**Application Reference:** 2025/0315

**Location:** 60 Intake Crescent, Dodworth, Barnsley, S75 3NW.

This application seeks planning permission for the demolition of an existing conservatory to the rear and the erection of a replacement single storey rear extension.

Drawing Title  
**PROPOSED ELEVATIONS**

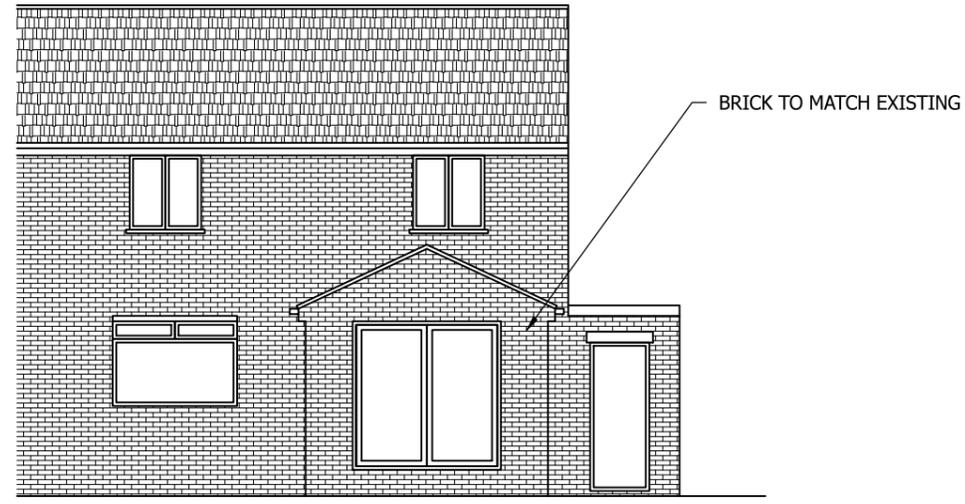
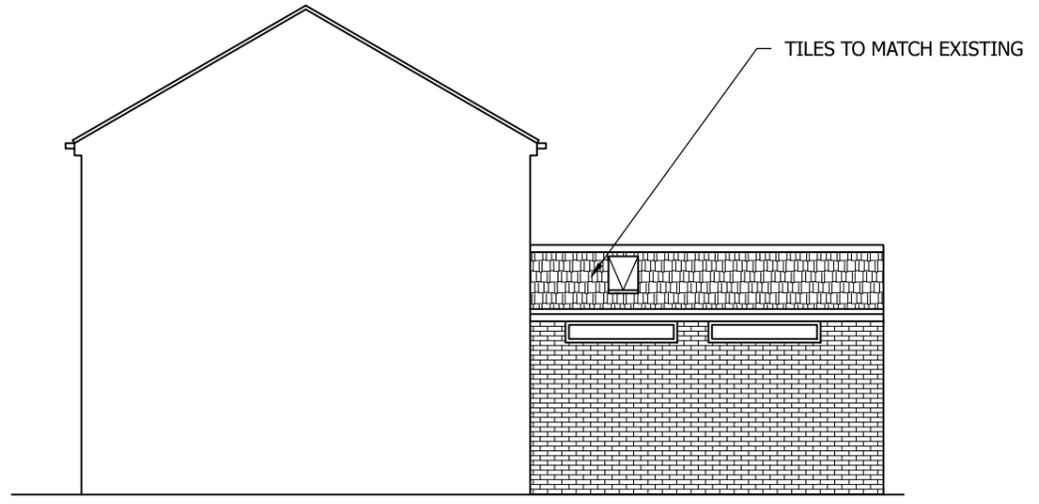
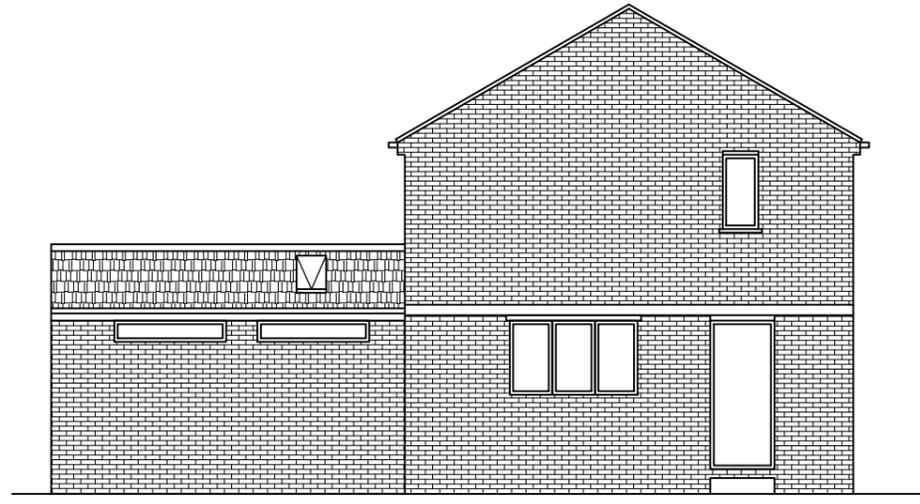
During the application process, the proposal was amended to remove a first-floor balcony because of concerns regarding overlooking and loss of privacy and increased noise and disturbance.

The House extensions and other domestic alterations SPD establishes that single storey extensions to the rear of semi-detached dwellings should not exceed 4 metres in projection and the eaves height should not exceed 2.5 metres where the extension would project beyond 3 metres. In this instance, the proposed extension would adopt a rearwards projection of approximately 5 metres and an eaves height of approximately 2.6 metres.

Regarding overlooking and loss of privacy, the proposed extension would feature glazed doors and small, highly positioned windows on its rear elevation and each side elevation respectively. It would also feature small roof lights on each roof plane. The development site is well-screened by existing

- *Omit a first-floor balcony atop the proposed extension because of overlooking concerns.*
